KITTTITAS COUNTY COMMUNITY DEVELOPMENT SERVICES

October 14, 2019

Subject: Rampart Row Preliminary Shore Plat (SP-19-00002) – Comment Review and Request for Additional Information

RAMPART ROW SHORT PLAT APPLICATION

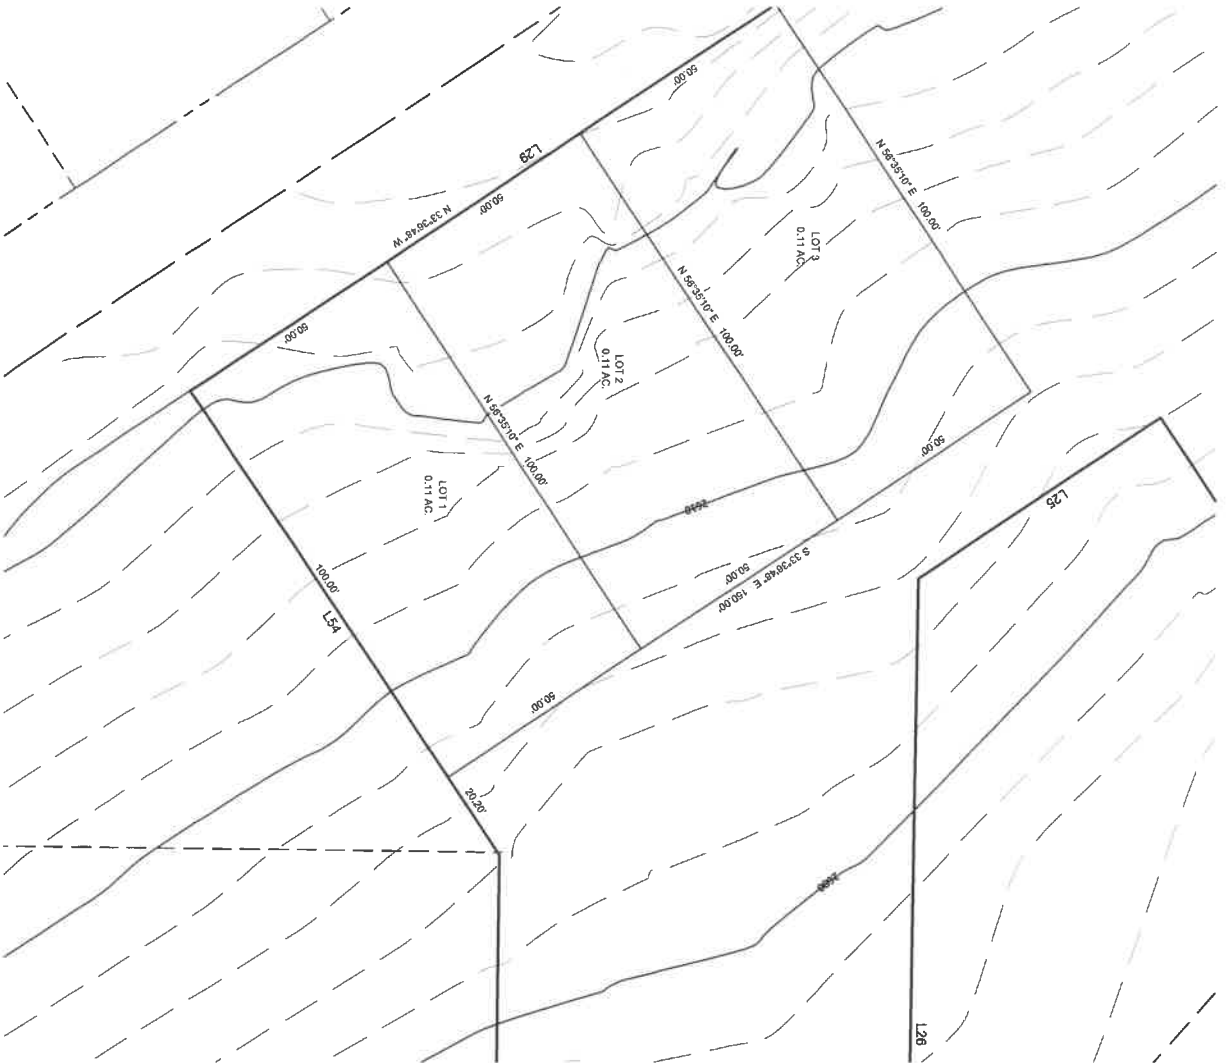
1. According to county critical areas mapping, it does appear that there is a type 4 stream identified in or close to lot 1 of the proposed short plat. Please provide documentation from a certified biologist confirming your proposed lots are clear of streams and any buffers associated with streams that may be adjacent to your proposed lots.
2. Pursuant to the Building officials' comments (enclosed), please update your plot plan to show how propane tanks will be able to meet the required setbacks.

1. Consideration should be given for the setbacks from propane tanks to buildings and property lines per the International Fuel Gas Code and the NFPA 58 current adopted versions at the time of permit submittals.
